Our ref: TR010064/Deadline 3

National Highways
Piccadilly Gate
Store Street
Manchester
M1 2WD
0300 123 5000
05/11/2024

TR010064 - M60/M62/M66 Simister Island Interchange EXAMINATION DEADLINE 3 SUBMISSIONS

-DR- Z -0004

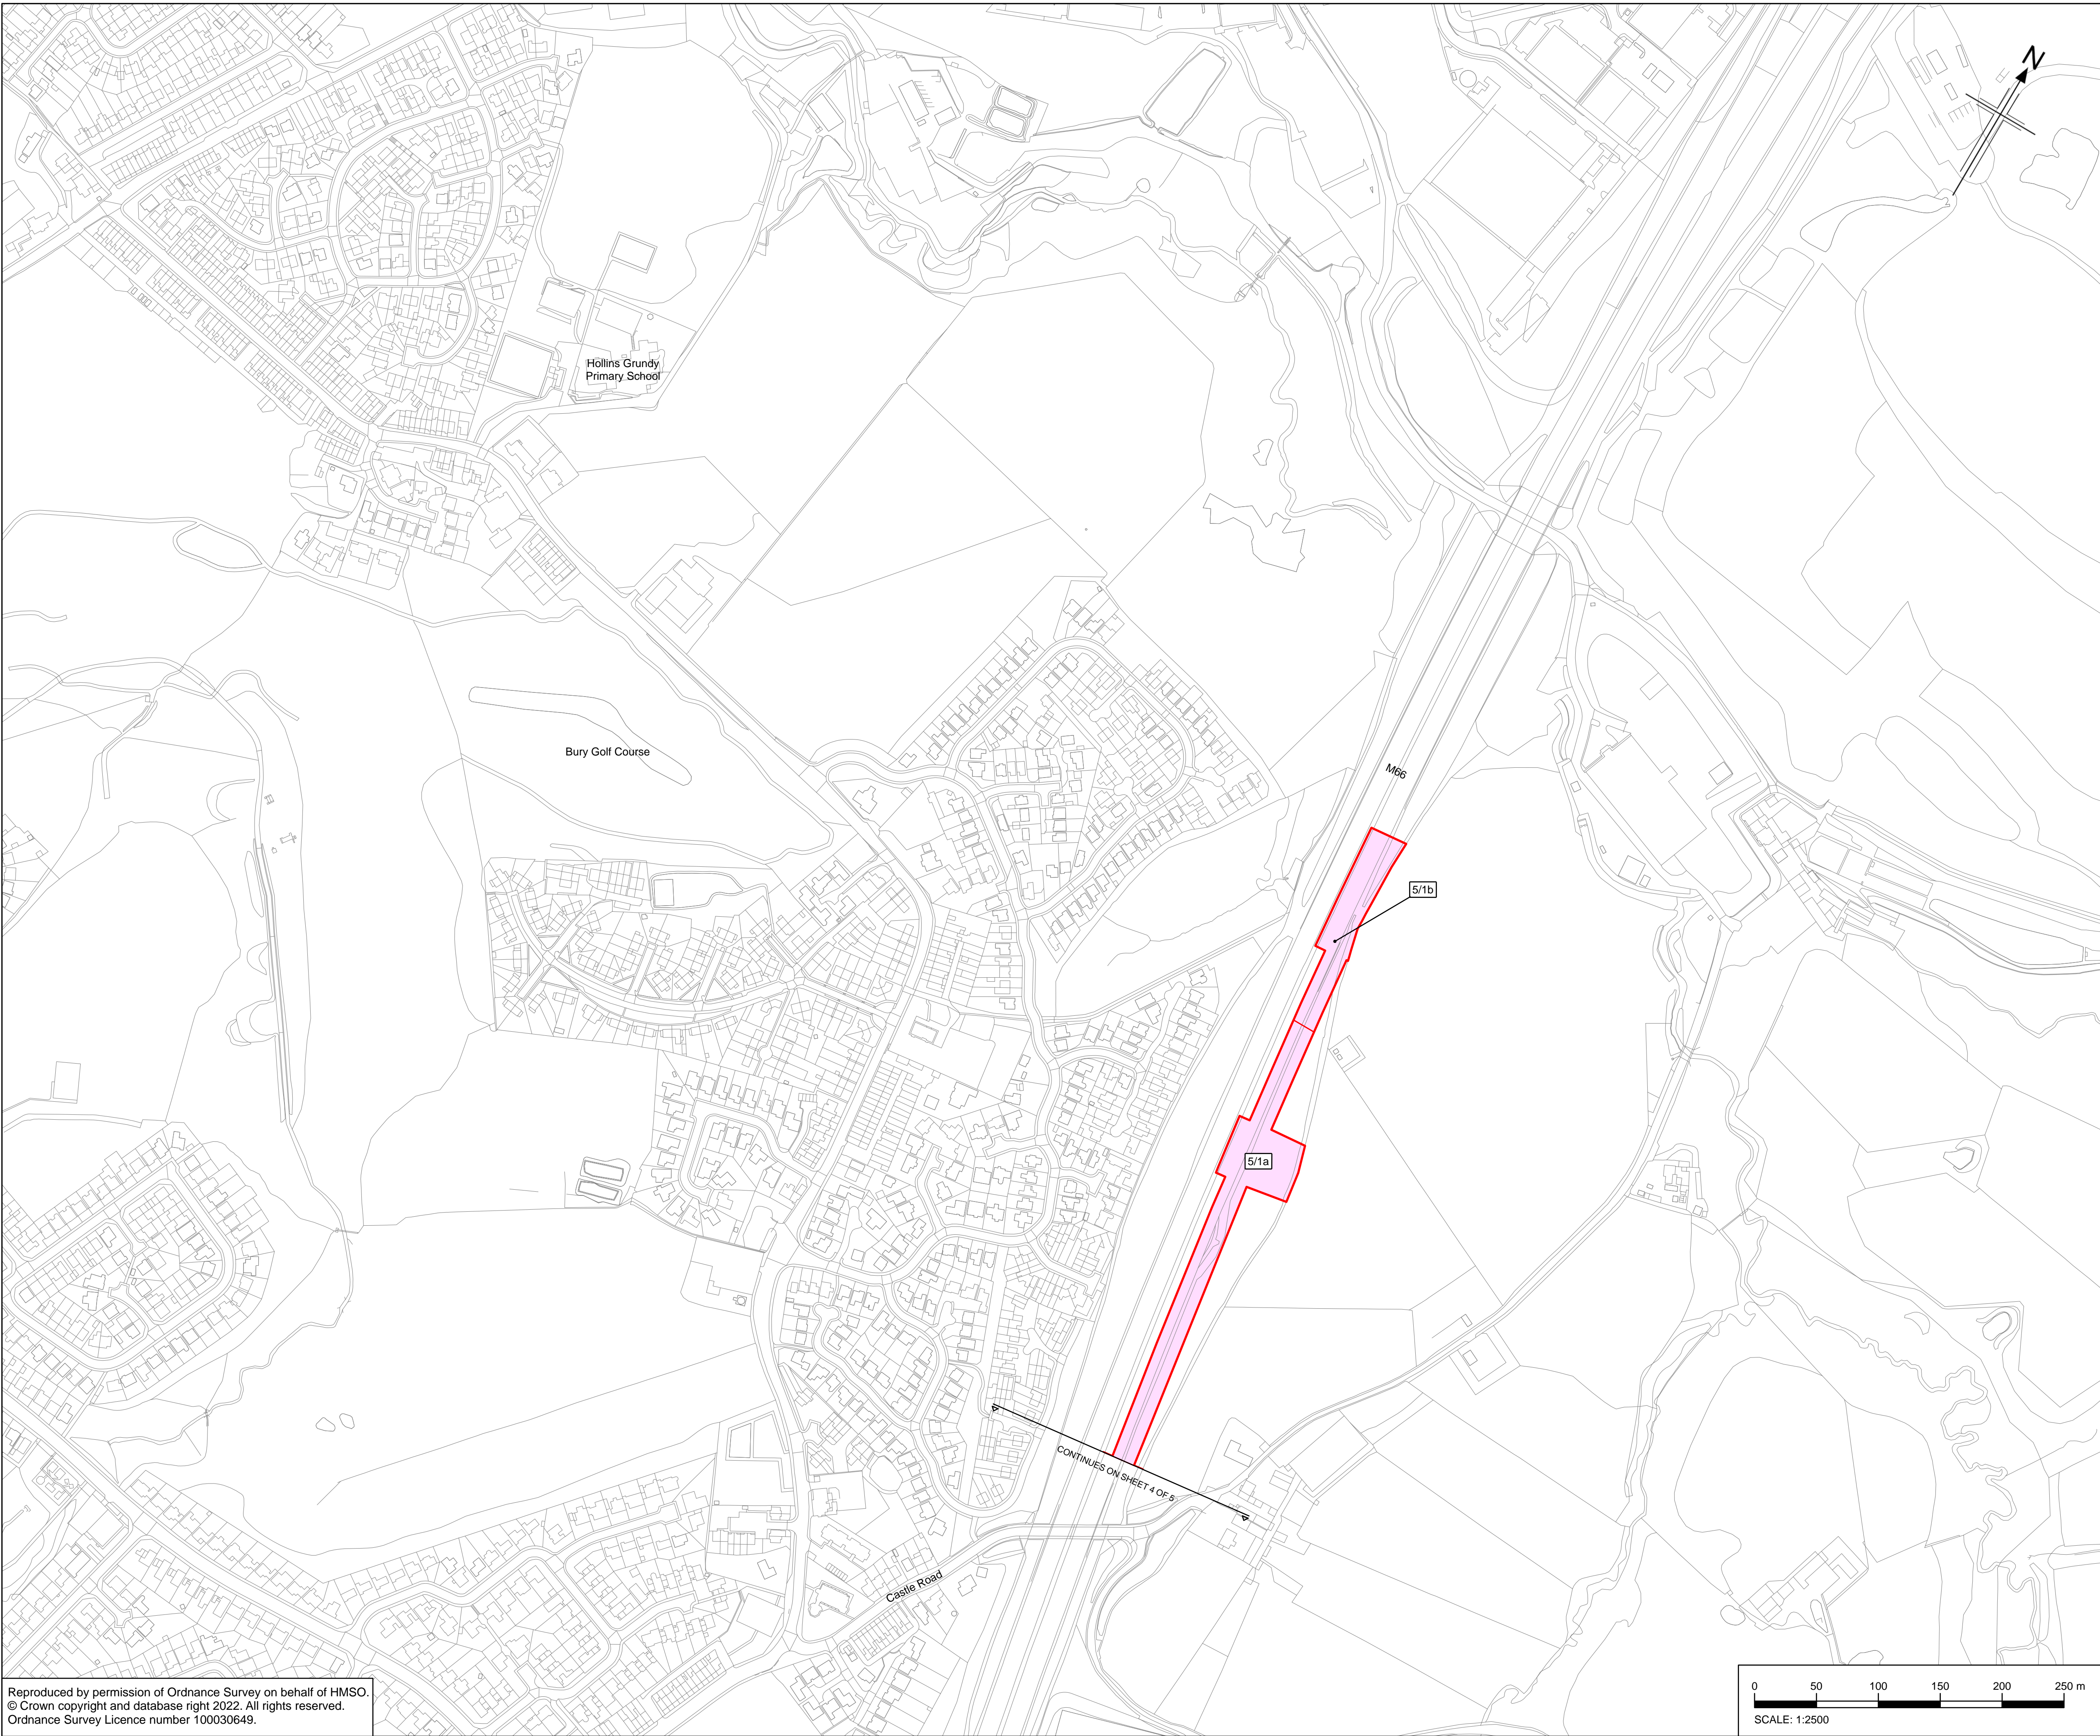
In response to ExA question *CA.1.4* revised Lands Plans [AS-005] has been provided to correctly label Plot 3/3. A further correction was identified and made to move the references for plot 2/1ax into Insets 2G and 2H.
